Report of the Head of Planning, Building Control, Sport & Green Spaces

Address CROMWELL HOUSE, 43 - 45 HIGH STREET RUISLIP

Development: Details pursuant to conditions 4 (Window Specification), 5 (Cycle Storage), 6 (Refuse Areas), 8 (Parking) and 10 (Landscaping) of planning permission ref: 12901/APP/2014/1734 dated 18/12/2014 (Change of use of first floor from Use Class B1a (Offices) to Use Class C3 (Dwelling Houses) to create 5 x 1-bed and 1 x 2-bed self contained flats involving alterations to windows to rear and side and replacement of existing windows, alterations to entrance area, installation of 10 rooflights to first floor roof to rear, replacement of rainwater goods and alteration to parking layout)

LBH Ref Nos: 12901/APP/2015/916

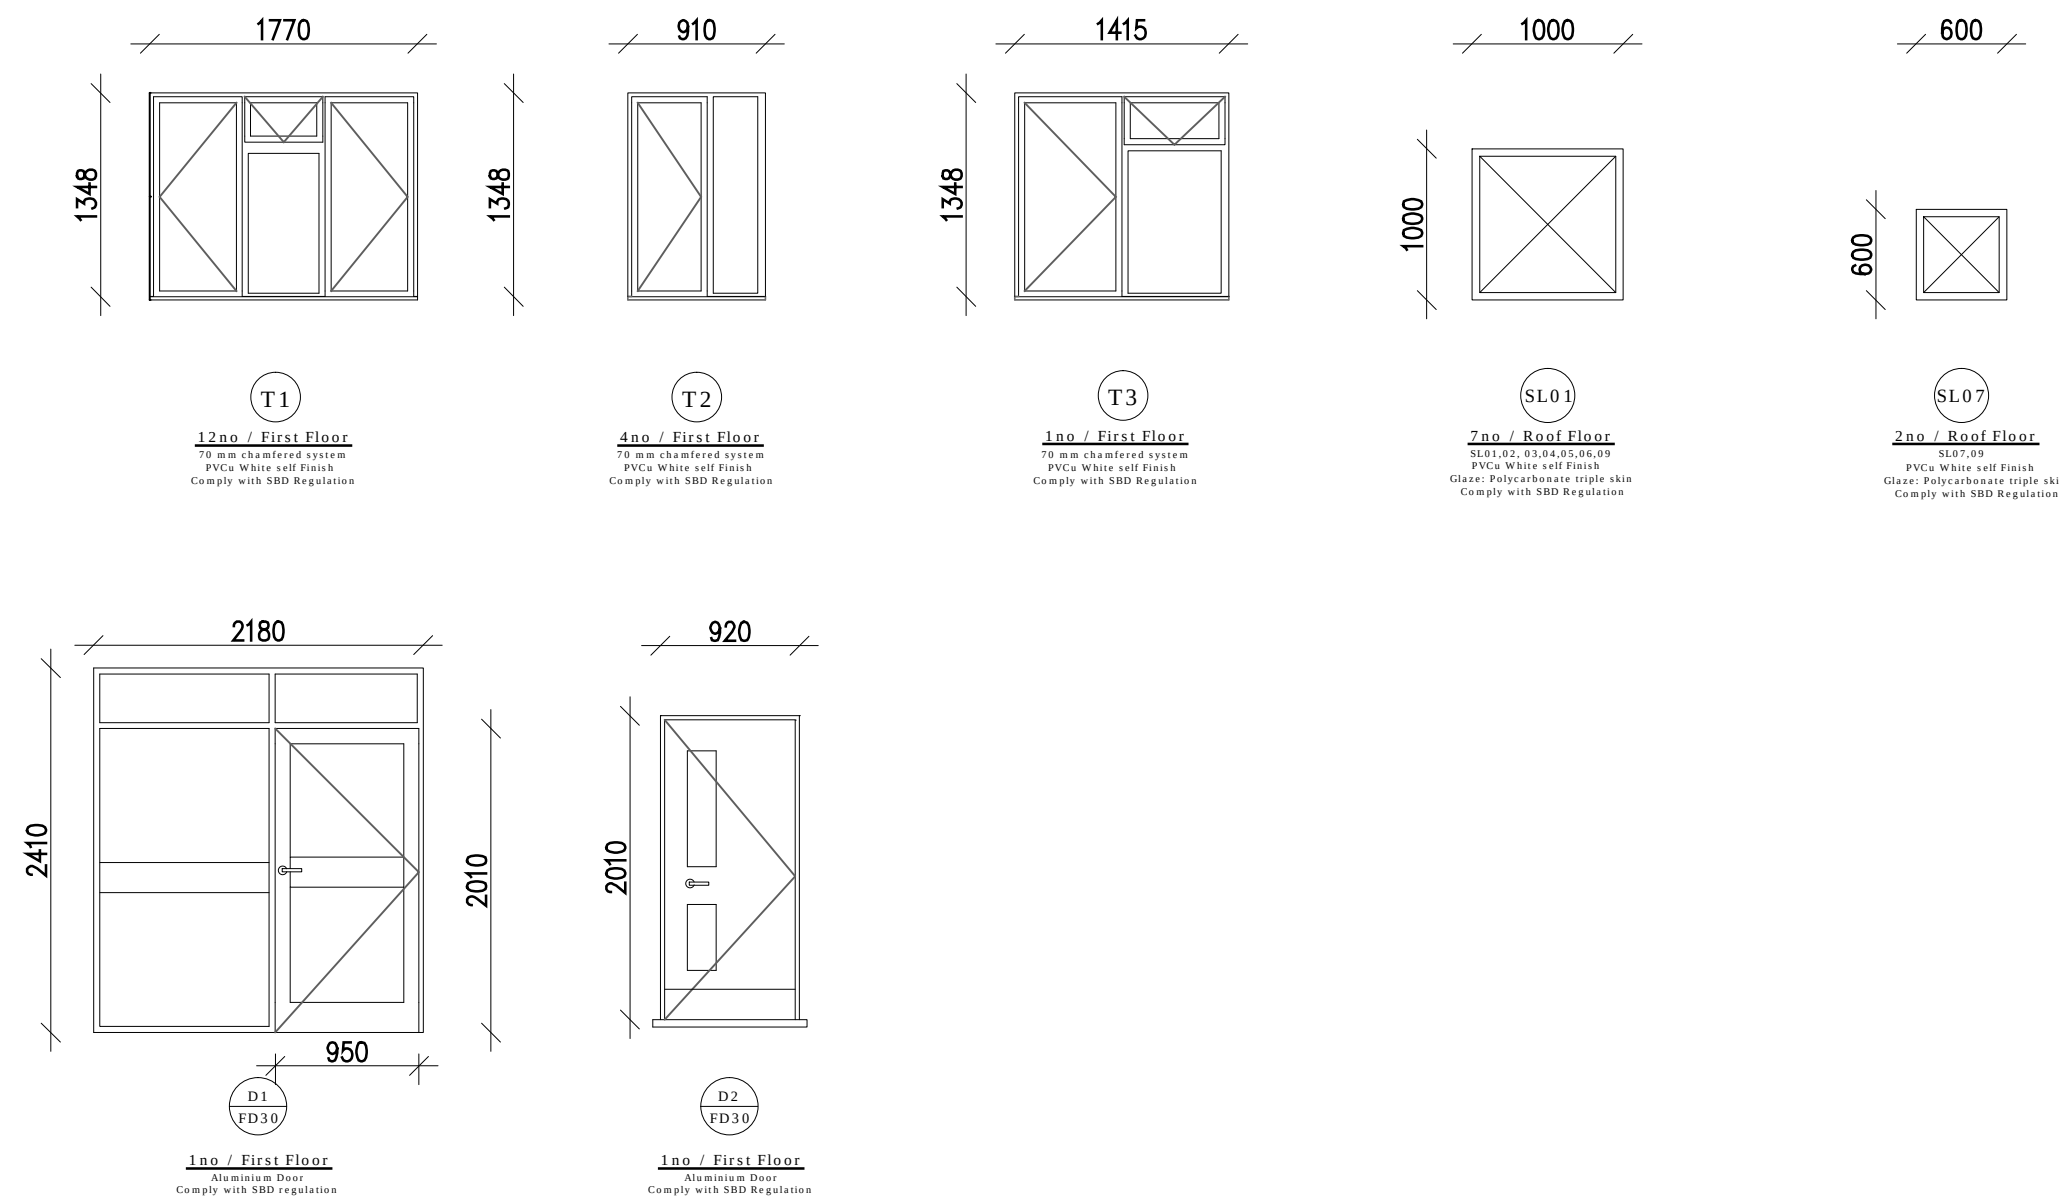
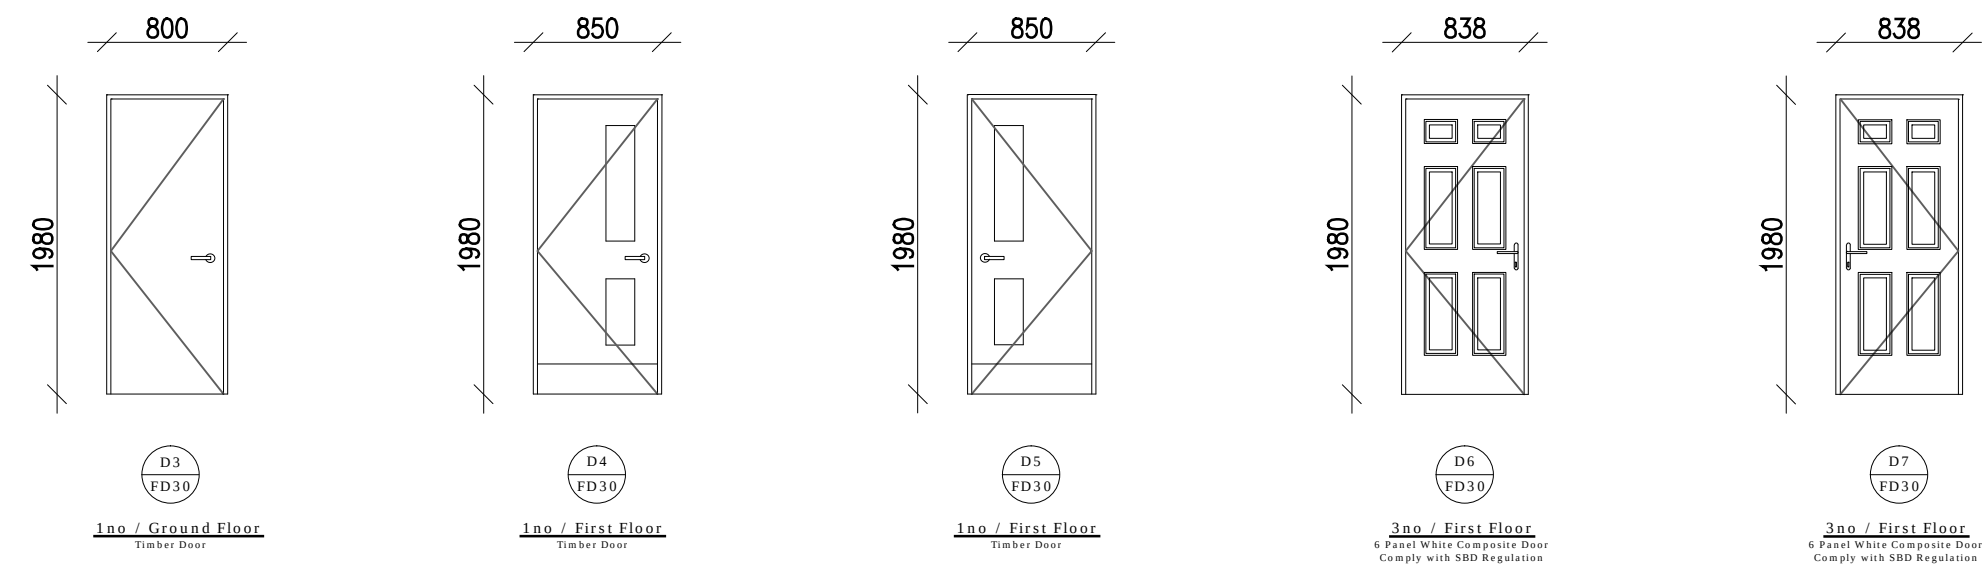
Condition 4 (Window Specification)- Drawing No. C.1.06 and NBS Specification shows detailed drawings of windows and doors proposed. The window details submitted by the applicant are considered suitable for this particular site and would not have an adverse impact on the appearance of the surrounding area.
